DEVELOPMENT REVIEW BOARD
TRANSPORTATION DEVELOPMENT

DRB Project Number: 1007489
West Route 66 Addition 2

SUBJECT: Preliminary/ Final Plat, Vacation Of Private Easements

Application #: 18DRB-70125 + 126

SHEET 1 OF 3

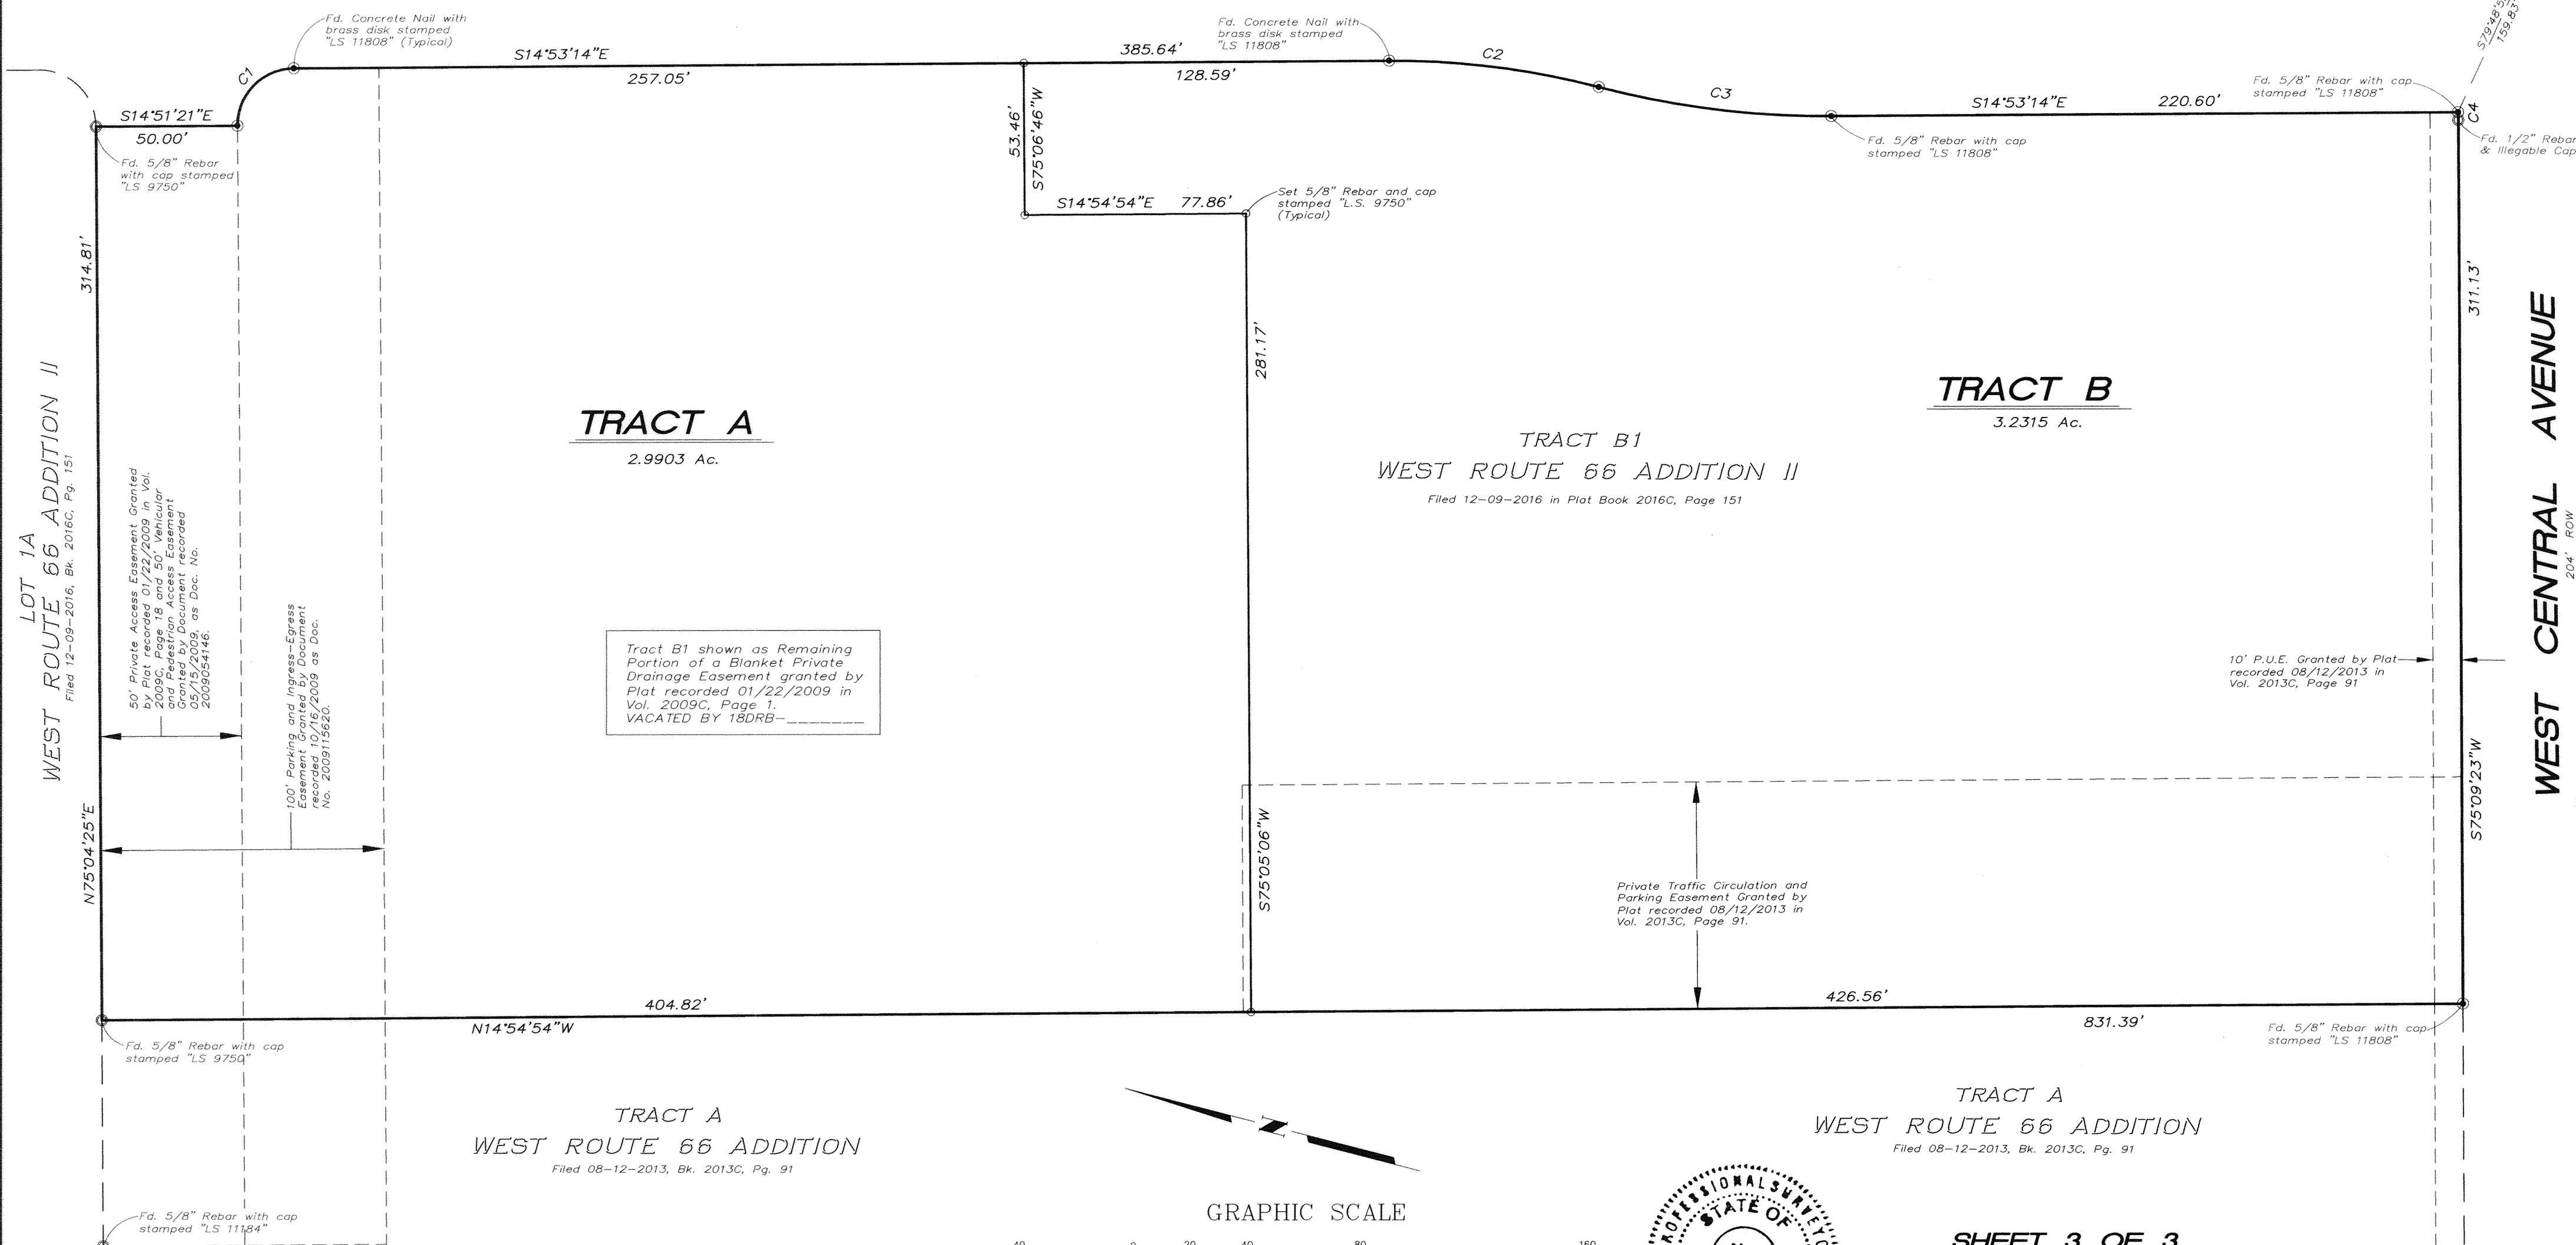
1. Verify where this development is located. The site plan is unclear, it should include the entire property.
2. The driveways located along Unser need to be closed.
3. For final plat, any access easements need to be shown with all beneficiaries and maintenance responsibilities listed.
4. Provide a sidewalk exhibit showing the location, width, and defining the distance from back of curb to the property line. Right of way dedication may be required.
